**PREFERRED PROJECT REPORT  
MAJOR PROJECT APPLICATION NO. 08\_0118**

**PROPOSED RESIDENTIAL SUBDIVISION  
AT LOT 4 DP 876253 WILLOW AVENUE  
BOGANGAR (SHIRE OF TWEED)**

**AUGUST 2010**

Ref. No.	Date	Drawing No./Size	Rev.
T14448	01/09/2008	17199 D	D

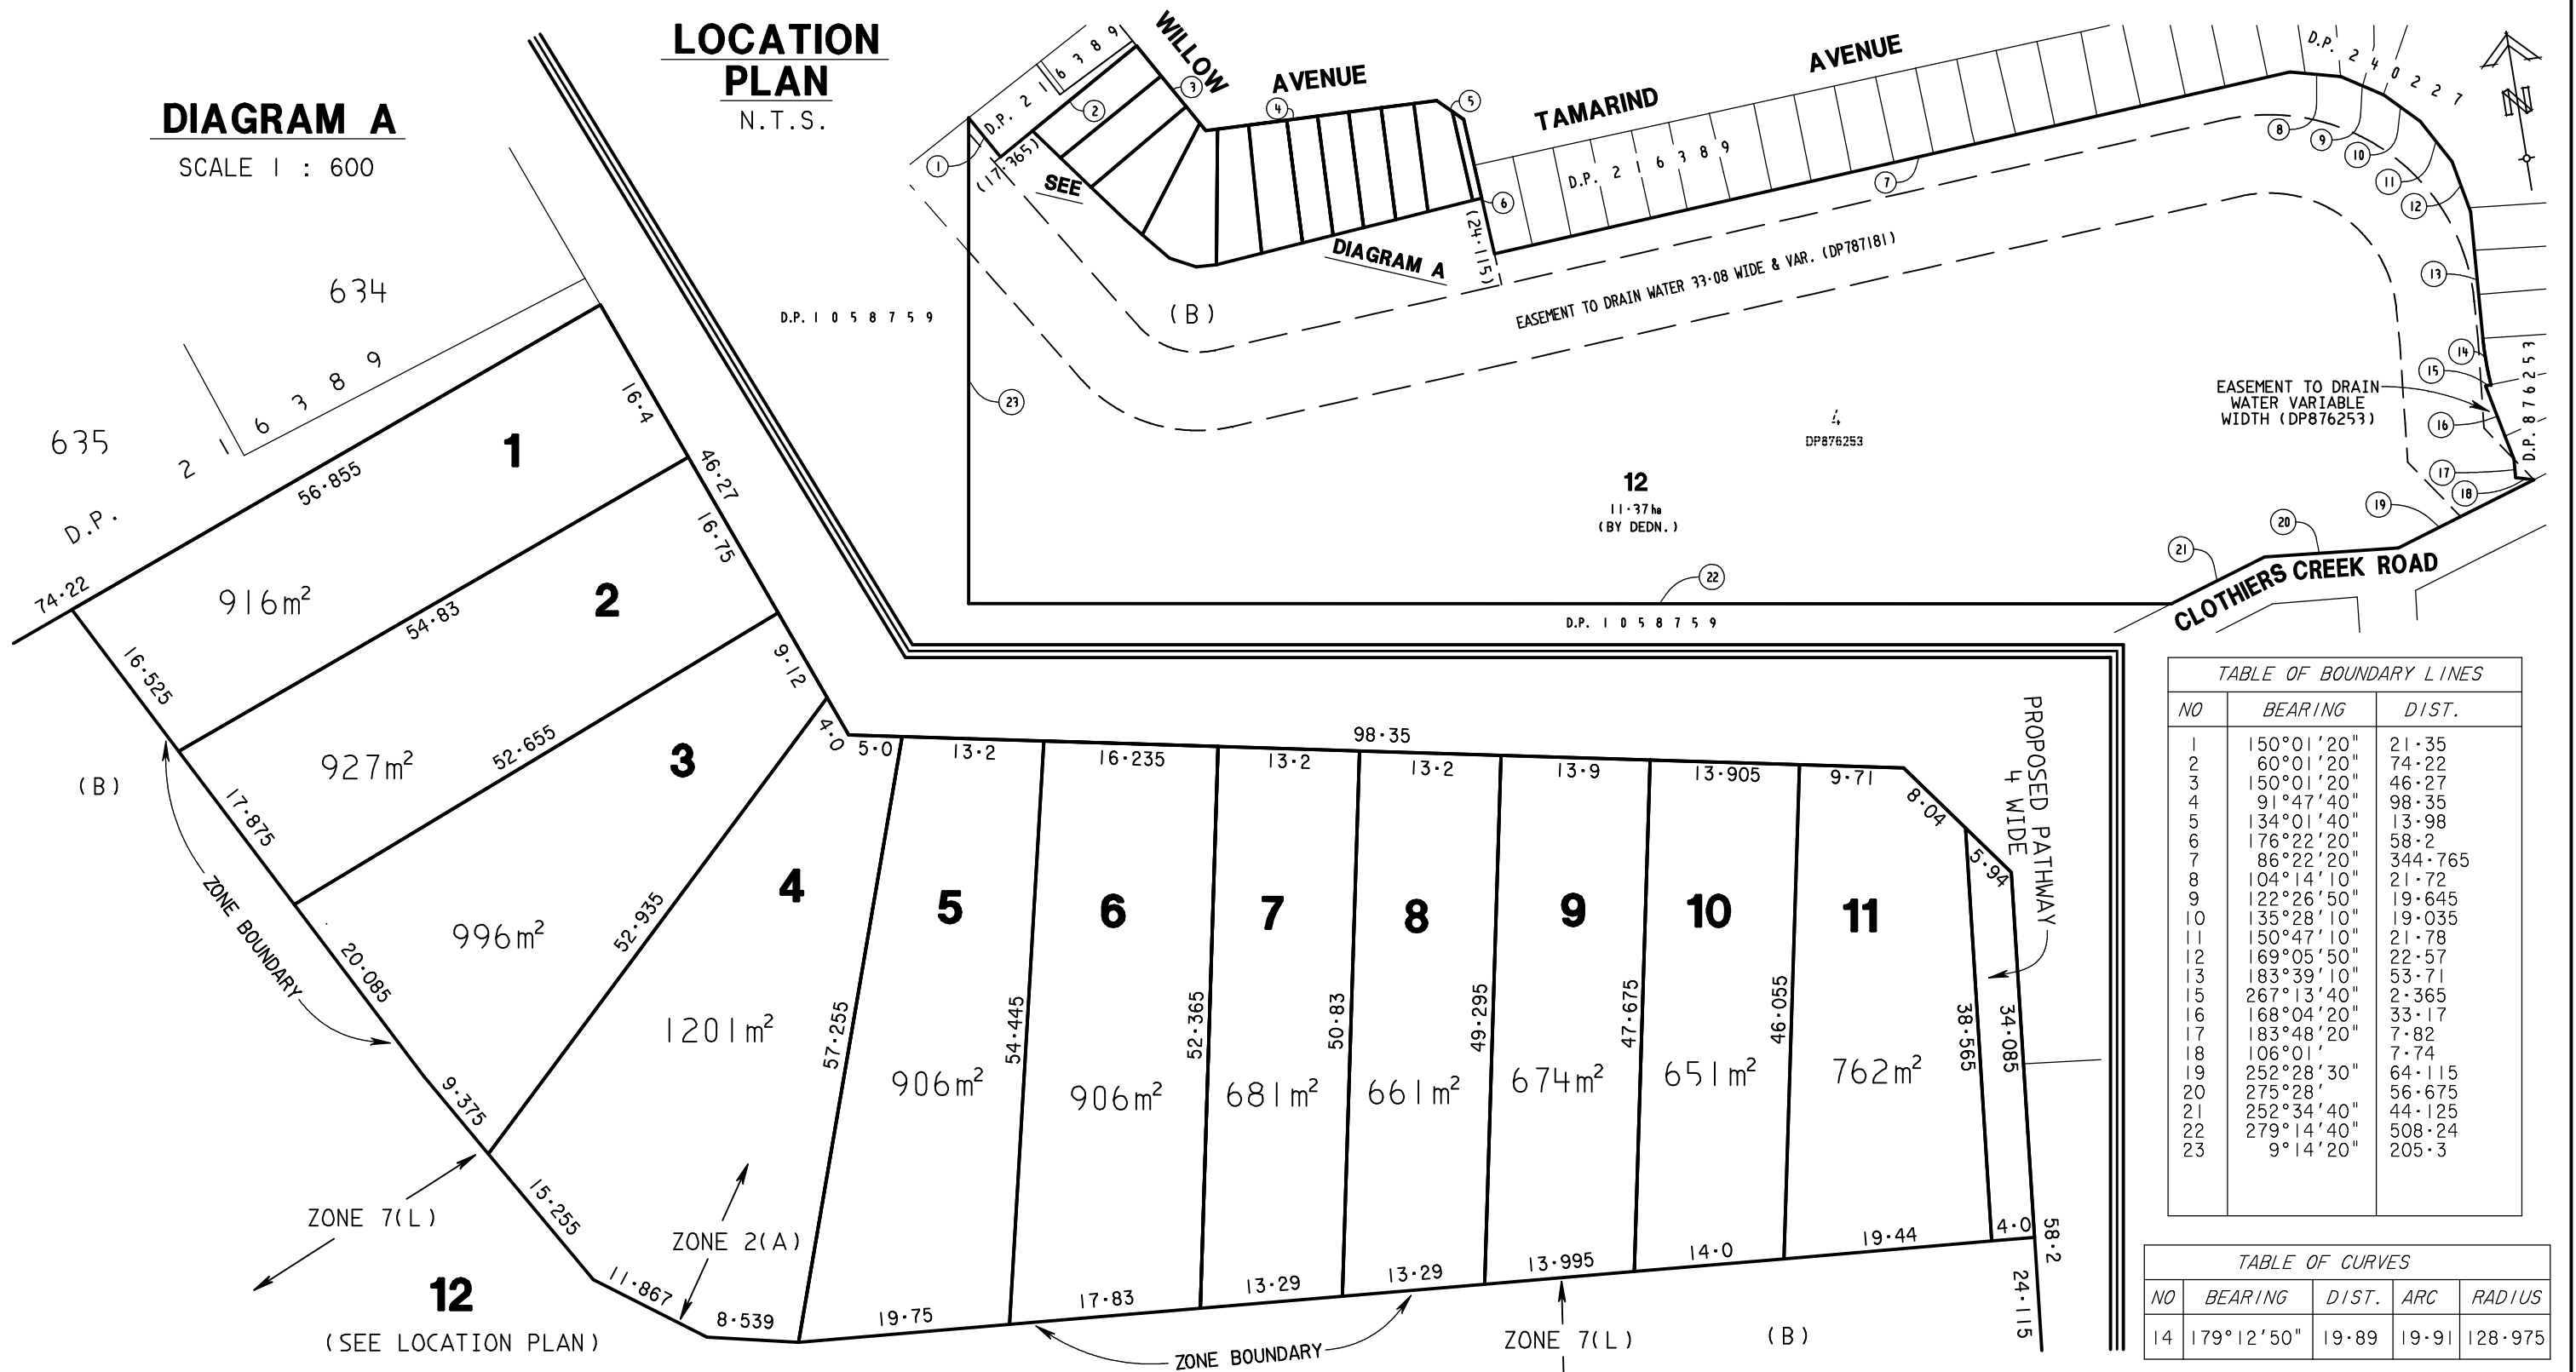
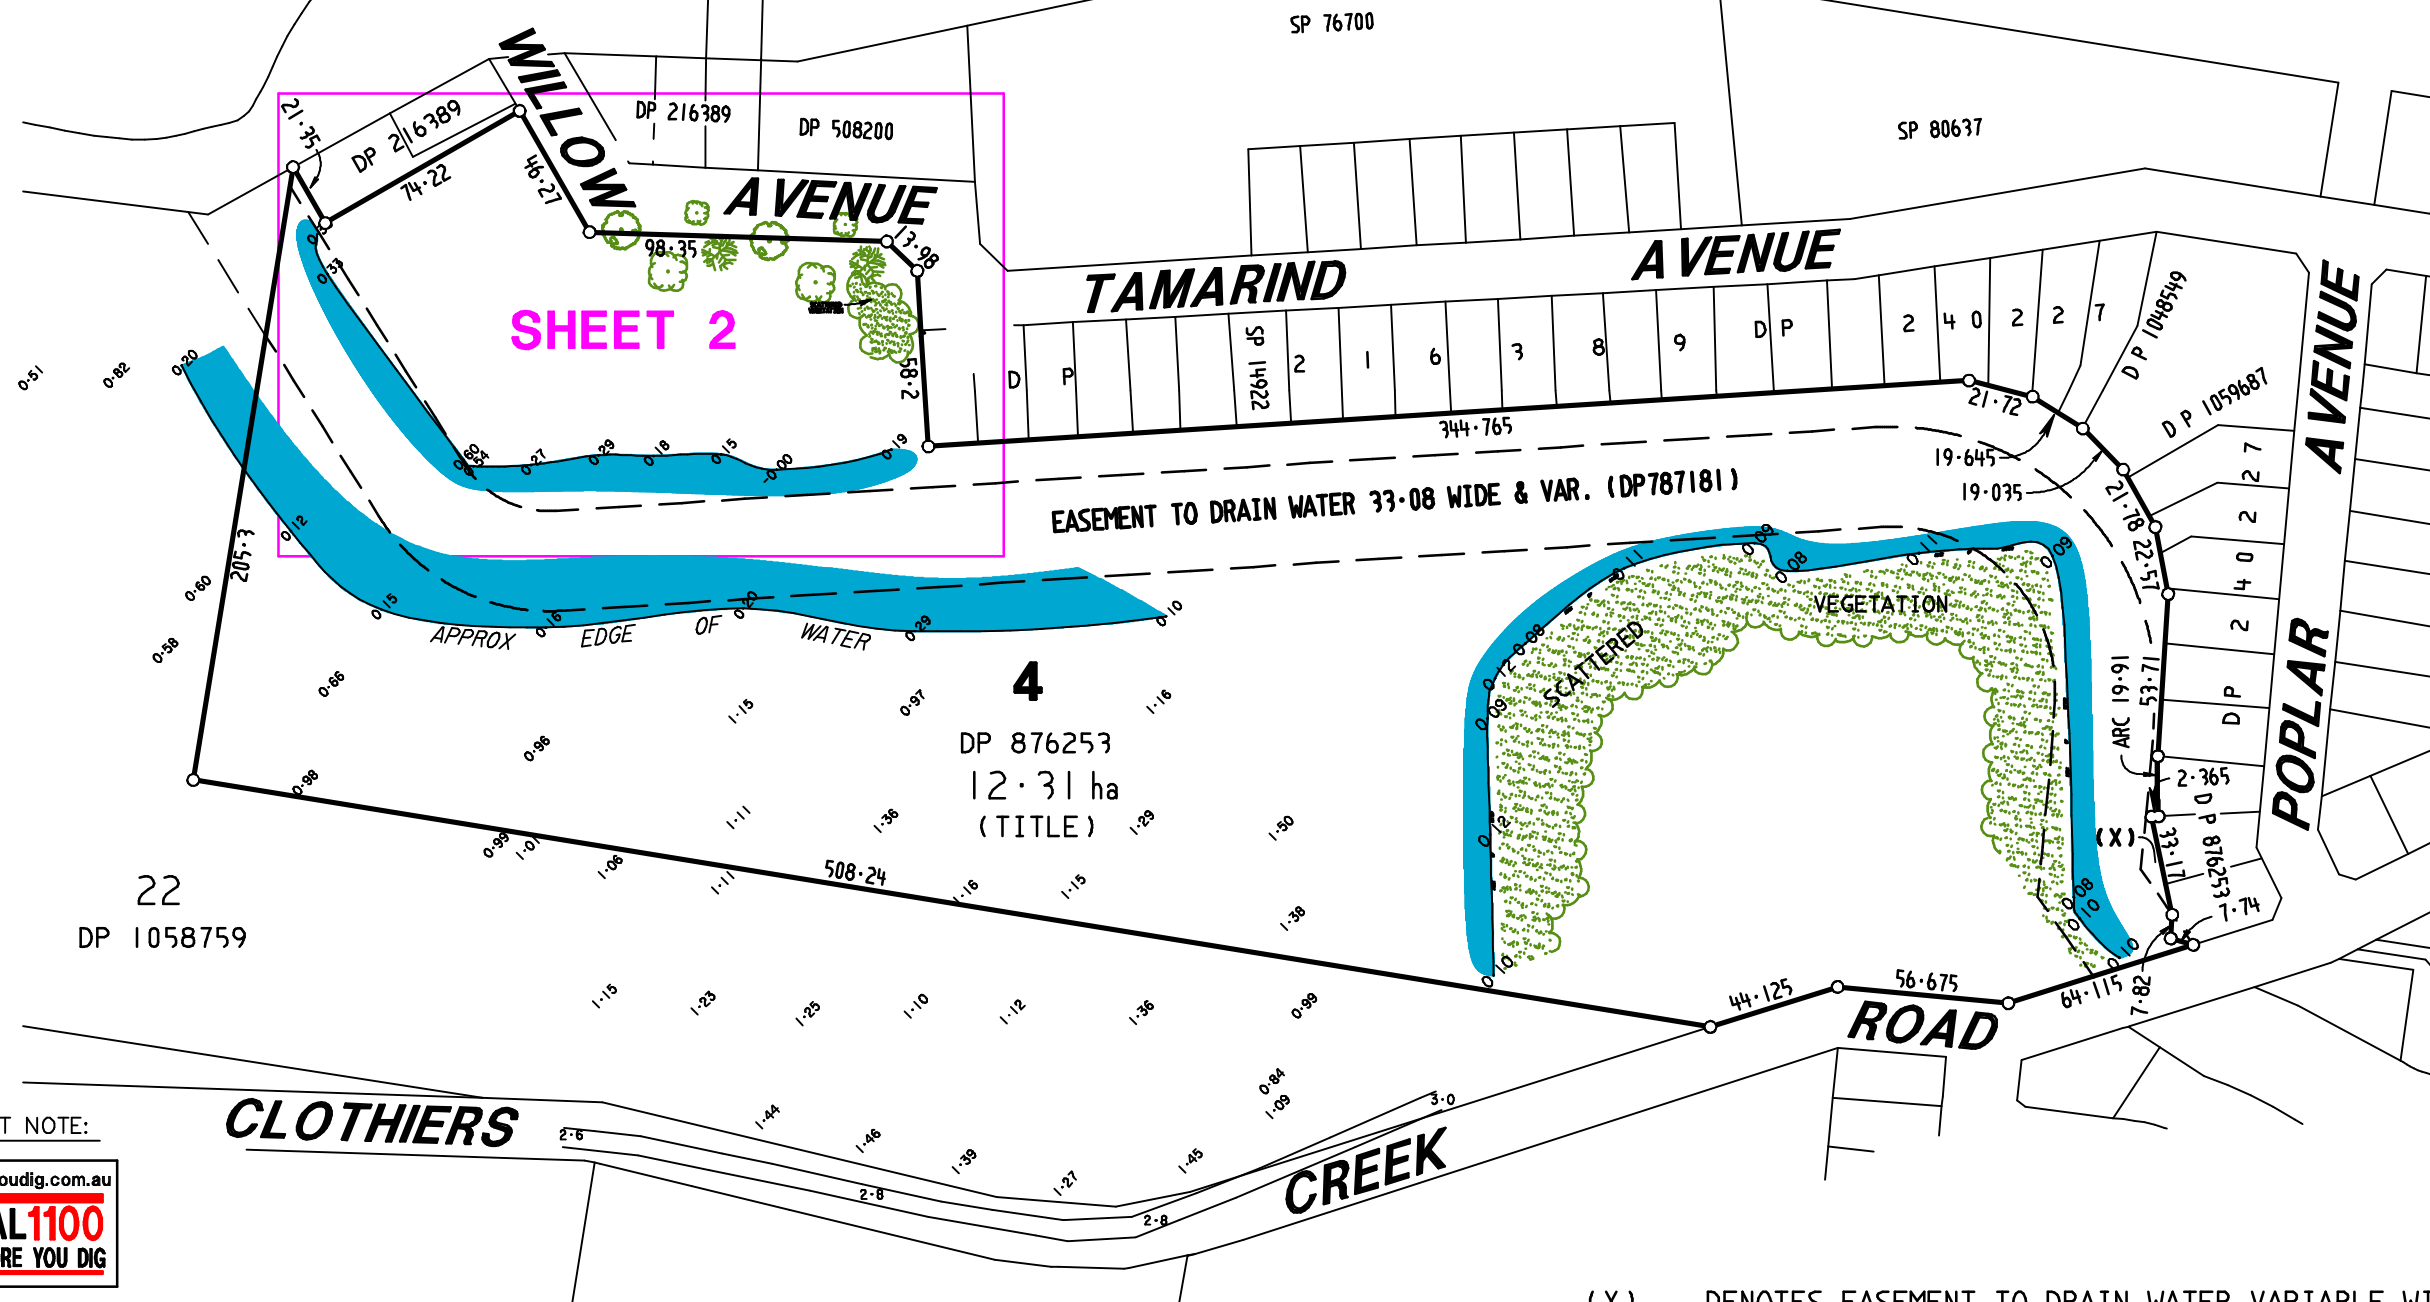
AGENCY RESPONSE	COMMENTS
<b>Planning Matters</b>	
<ul style="list-style-type: none"> <li>It is considered that proposed Lot 12's configuration is not appropriate given that it only has minimal road frontage and requires a right of carriageway to gain lawful access.</li> </ul> <p>Also, the orientation of this allotment is not desirable given the close location of Council's sewerage pump station. Council will also require constant access to the sewerage pump station for maintenance and future upgrading works and it is considered that the orientation of the allotment may obstruct these activities.</p>	See Amended Plan of Subdivision at <b>Annexure 1</b> .
<ul style="list-style-type: none"> <li>It is considered that proposed Lots 3 and 4 do not achieve good planning outcomes as the nominated lot frontage for these two lots are only 4.0m in width. As this is a greenfield development, it is considered that it would be a better planning outcome if the frontages were wider than 4.0m and have a more regular configuration.</li> </ul>	The Amended Subdivision Layout Plan at <b>Annexure 1</b> provides for a 9.12m alignment frontage for Lot 3 and a 6.75m alignment frontage for Lot 4. Clearly, the frontage at the building line (ie. 6m from the street alignment) will be more than adequate to enable a compliant dwelling to be sited.
